July 28, 2022

**SUBJECT: Monument Academy Subdivision
Response to County Review Comments
MS-21-010**

In conjunction with the re-submittal for this Subdivision, this letter provides responses to the review comments detailed in the Memorandum from PCD-Engineering dated June 1, 2022. These review comments are specifically addressed as follows **(Applicant responses are annotated in bold / red / parenthesis following each County comment):**

MA SUBDIVISION

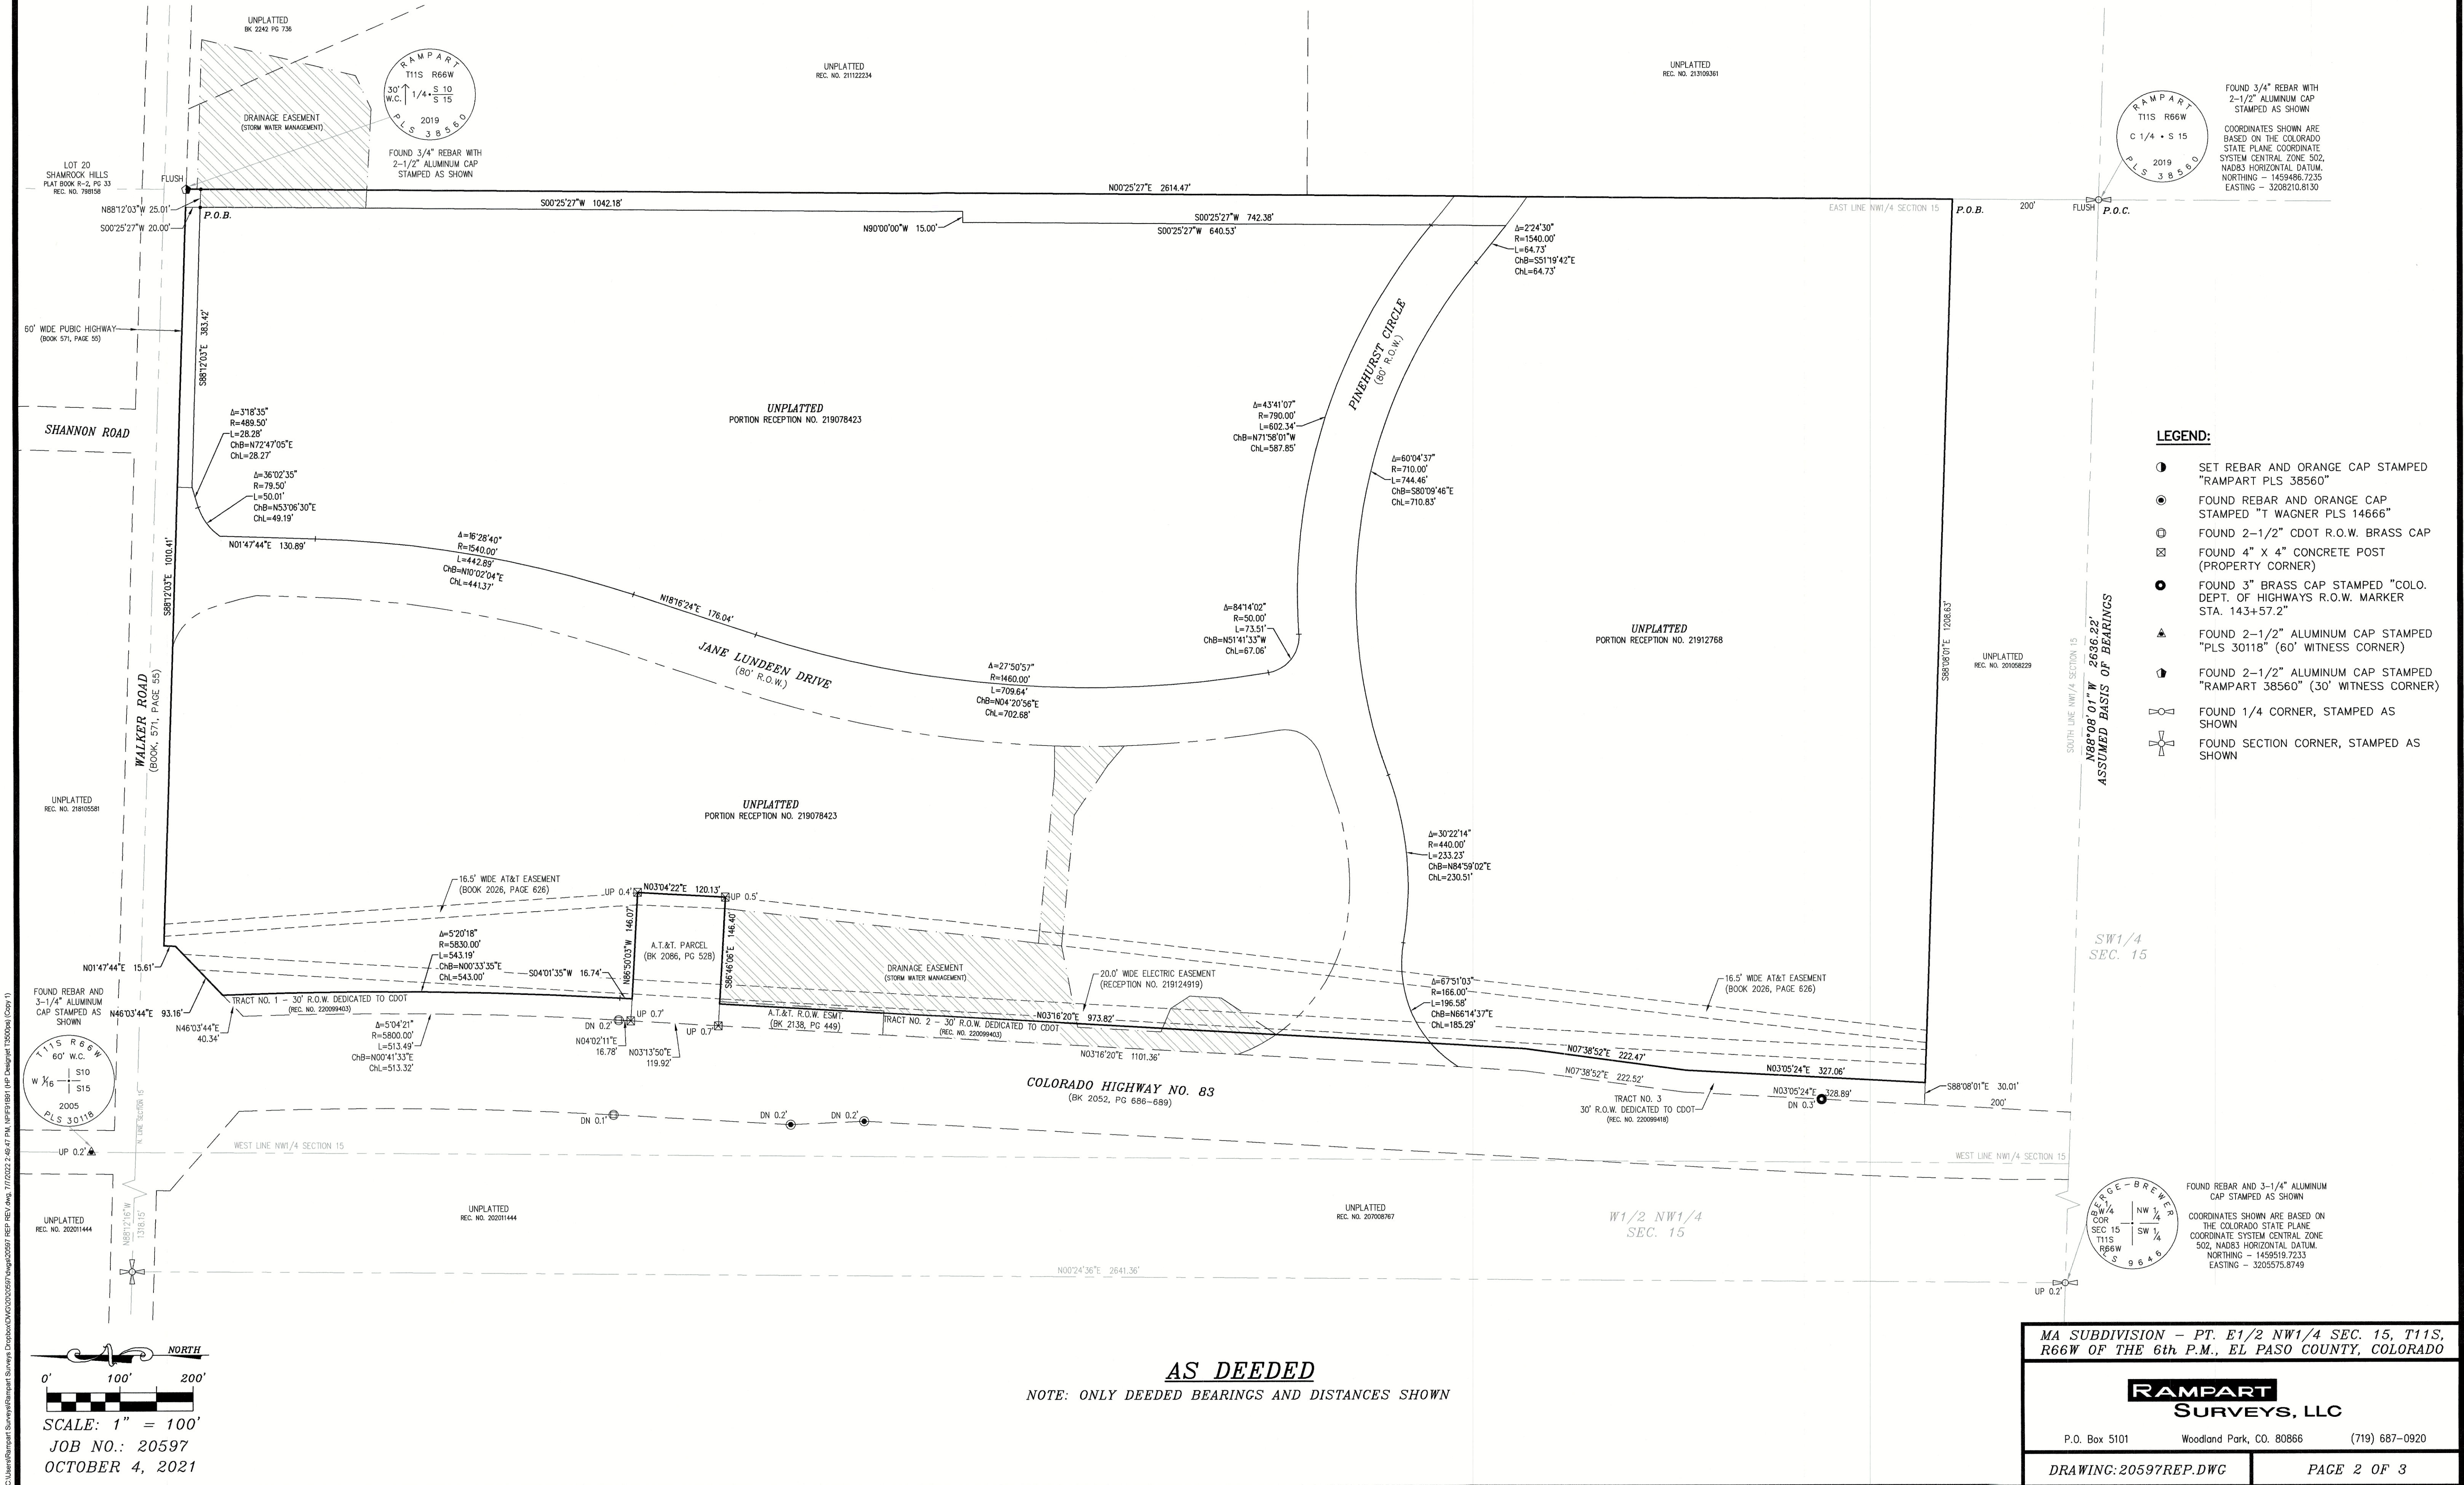
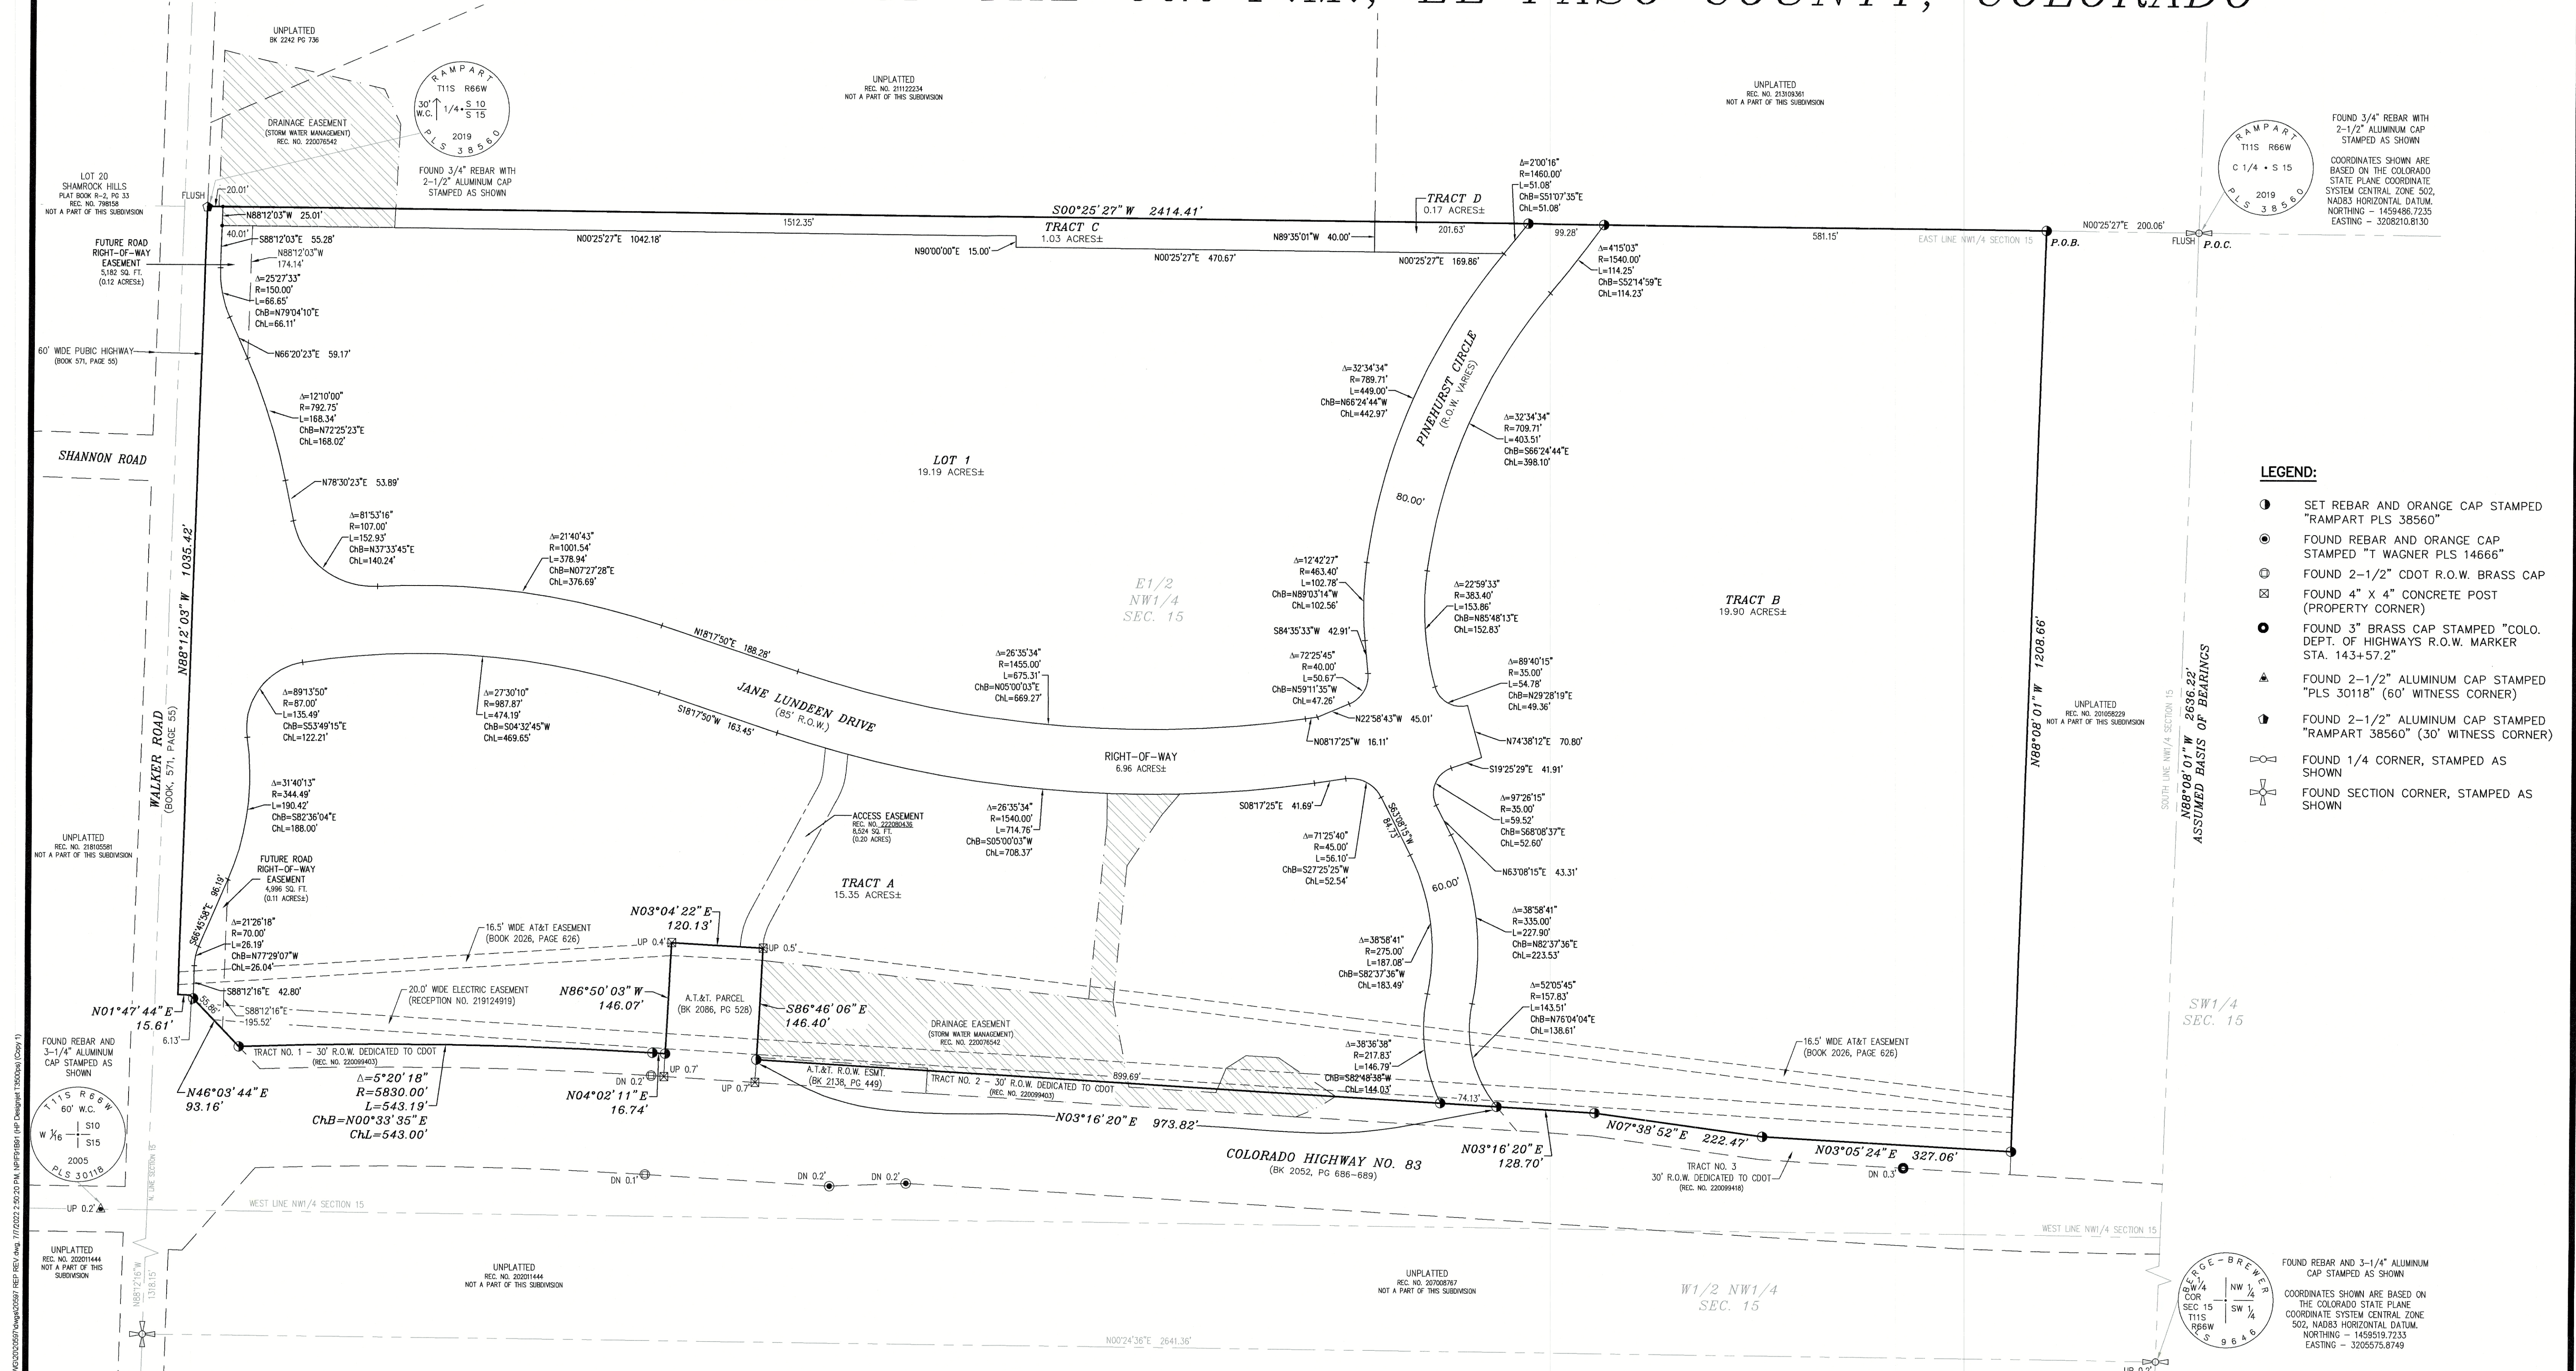
1. See plat redlines (sent by Planner). **Partially resolved; see updated/remaining redlines. (Remaining redlines have been addressed)**
2. Ensure any and all existing utility easements under the proposed ROW are vacated. (DA paragraph #3).
